Our Ref: LM/ARU/20/05B

Date 12th January 2022

RE: Land North of Lee's Yard Lidsey Road Woodgate PO20 3SU

Thank you for your correspondence of the 11th of January 2022, advising me of a planning application for approval of reserved matters following outline planning permission AL/21/20/OUT for the approval of the appearance, layout, scale and landscaping for 5 No 4-bed dwellings, 14 No 3-bed dwellings & 19 No 2-bed dwellings. This site is in CIL Zone 3 and is CIL Liable as new dwellings at the above location, for which you seek advice from a crime prevention viewpoint.

2. Play Strategy

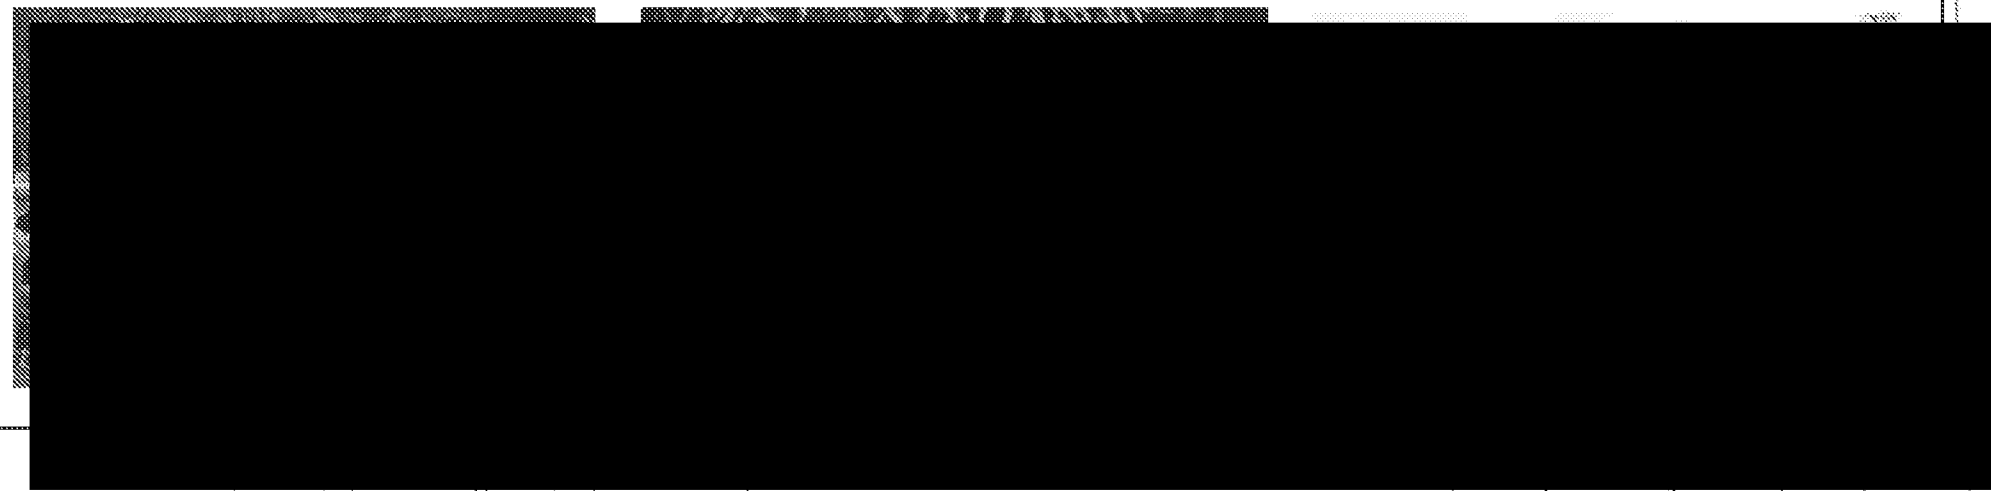
In relation to the LEAP - areas of play should be situated in an environment that is stimulating and safe for all children, be overlooked with good natural surveillance to ensure the safety of users and the protection of equipment, which can be vulnerable to misuse. They should be designed to allow natural surveillance from nearby dwellings with safe and accessible routes for users to come and go. Boundaries between public and private space should be clearly defined and open spaces must have features which prevent unauthorised vehicular access. I would ask that the LEAP is surrounded with railings with self-closing gates to provide a dog free environment.
